Subject: RE: Request for further information P/55/20/HH

From: Chris M
Sent: 24 June 2020
To: Sian Egging
Cc: 'Shaun Tay
Subject: FW: Request for further information P/55/20/HH

Thank you for the letter – in reply to your comments;-

GROUND FLOOR PLAN

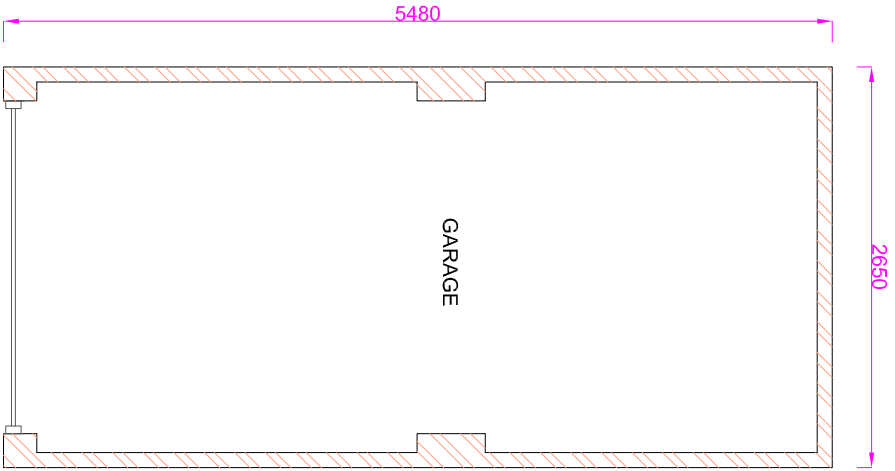
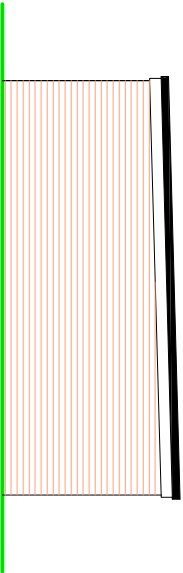
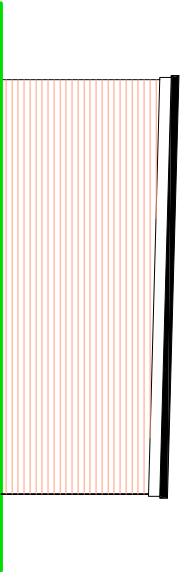
Room Labels: You are required to have room labels on all floor plans. Please amend. – Amended.

Site Plan (scale 1:500)

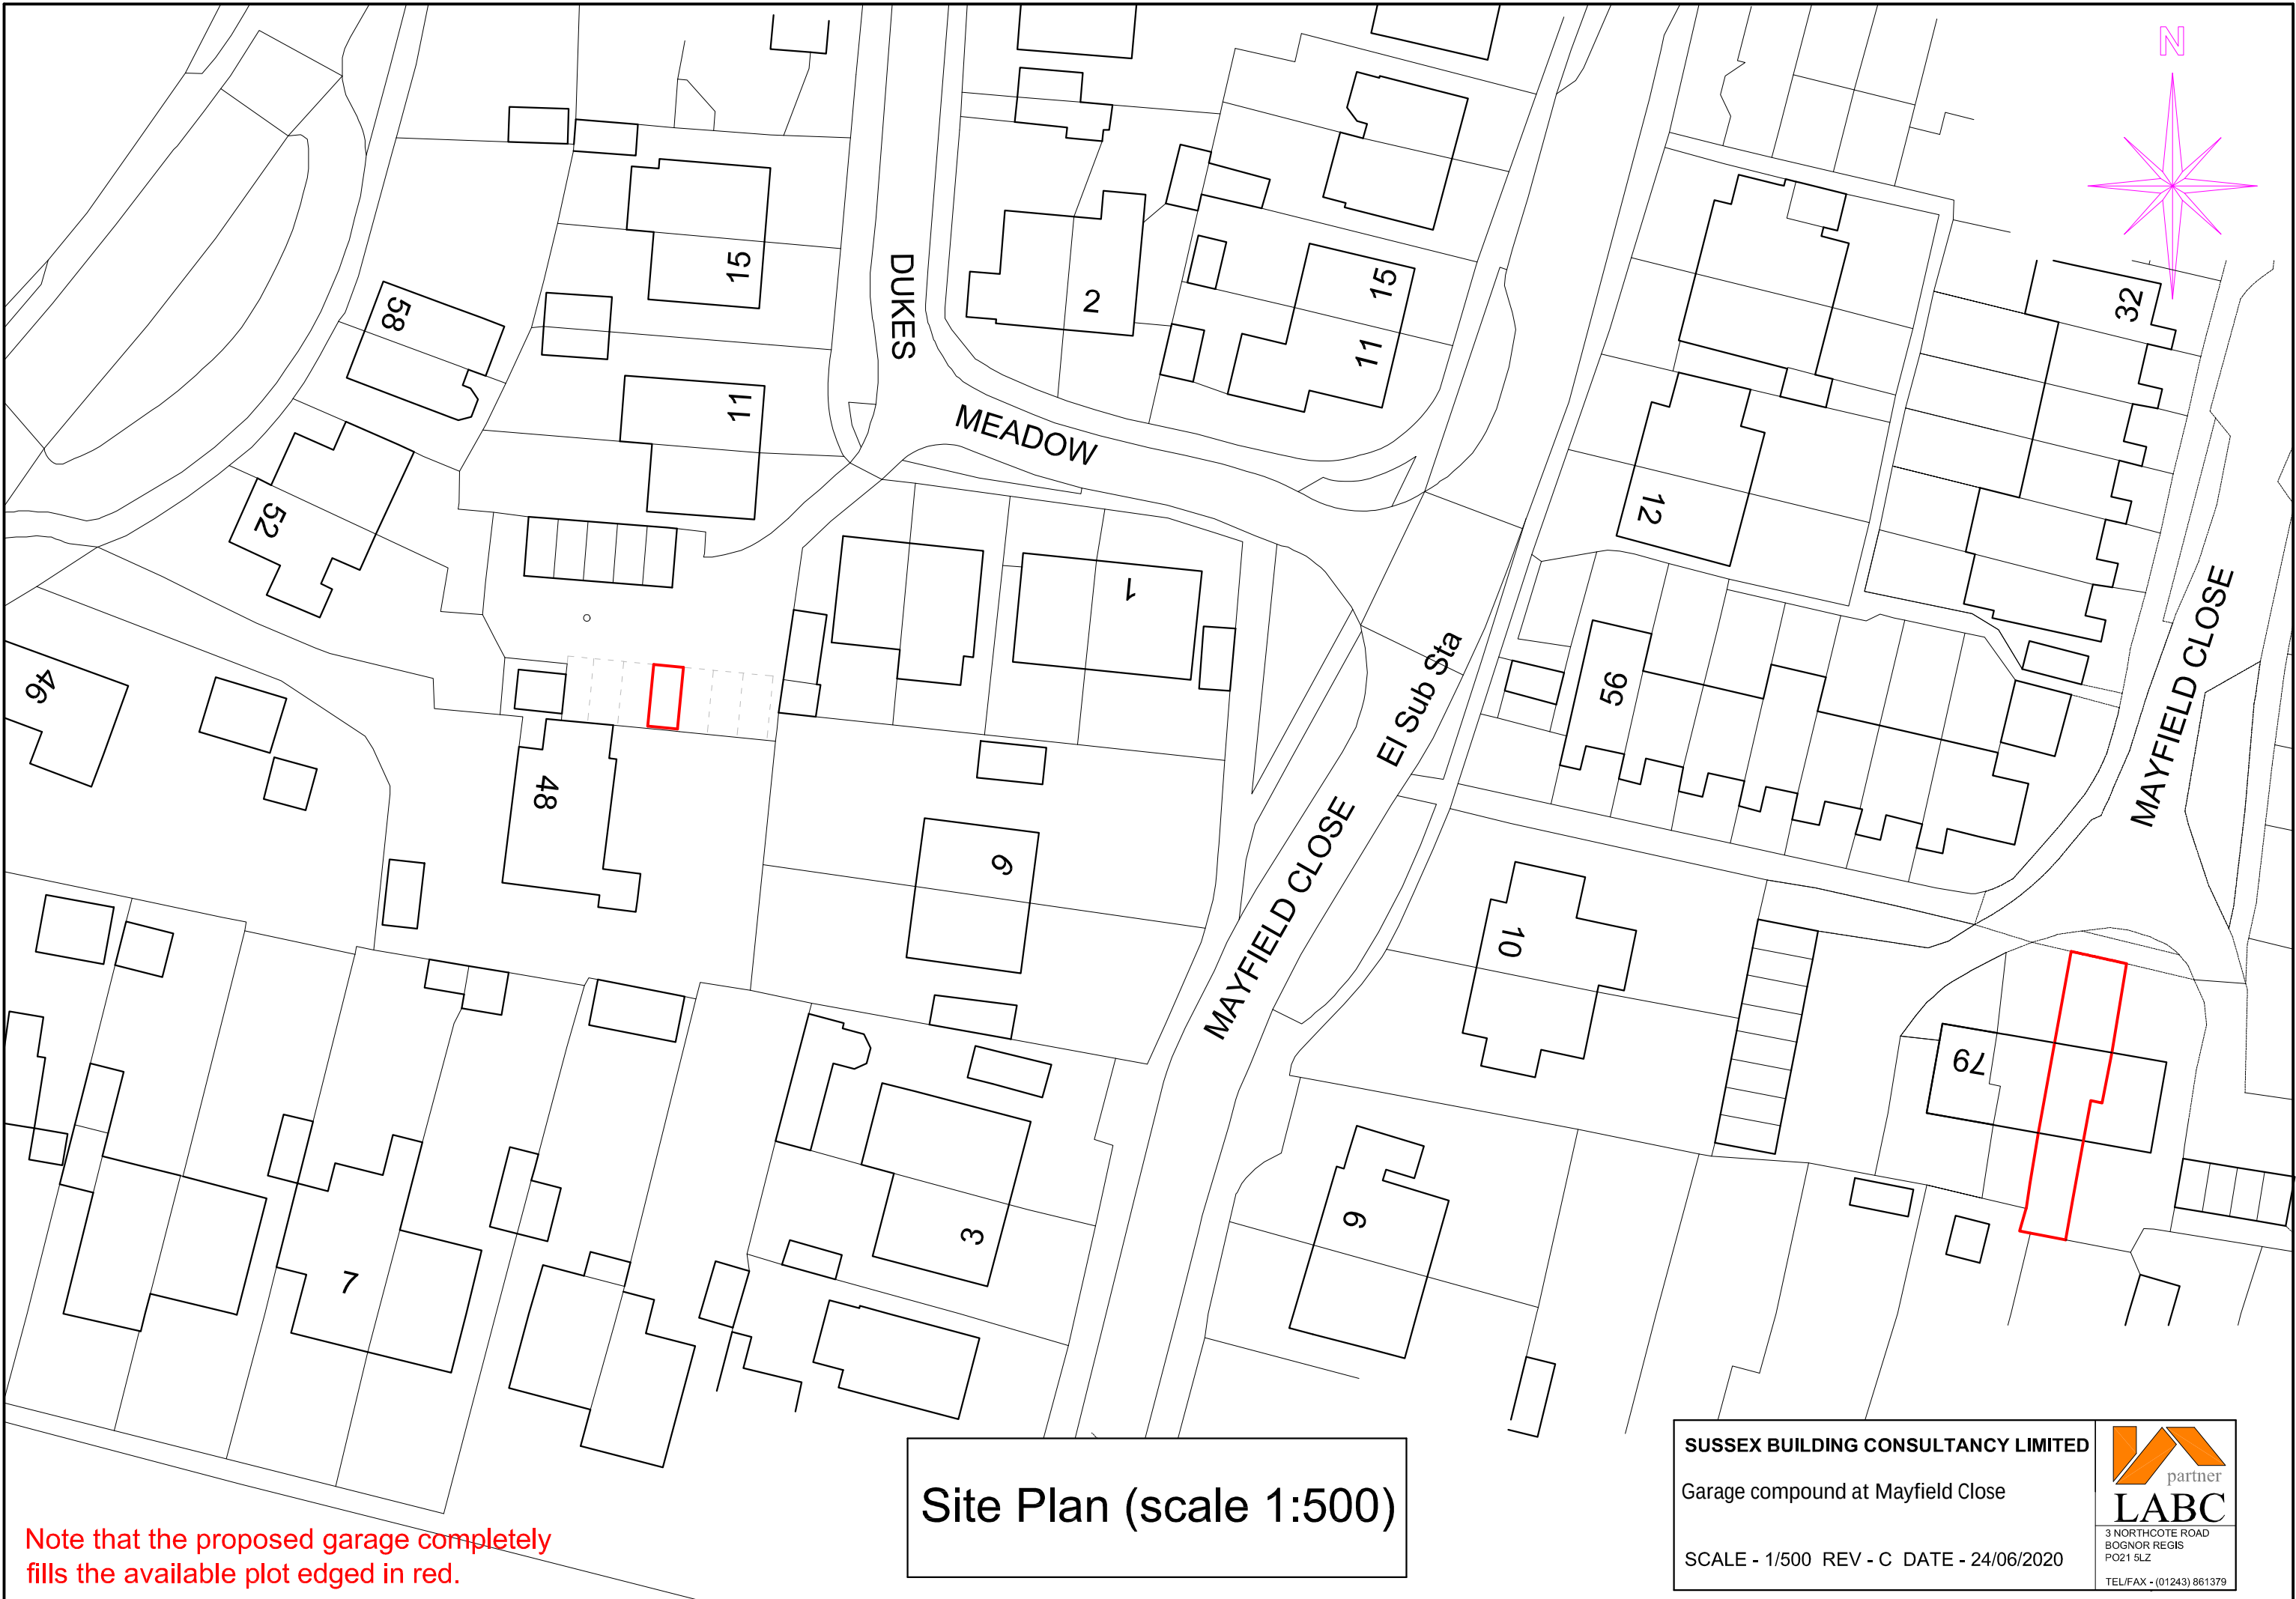
Block Plan: Please submit a proposed block plan with dimensions to all site boundaries. – The new garage completely fills the available plot size so no distance to boundaries – I have put a note in RED on the site plan.
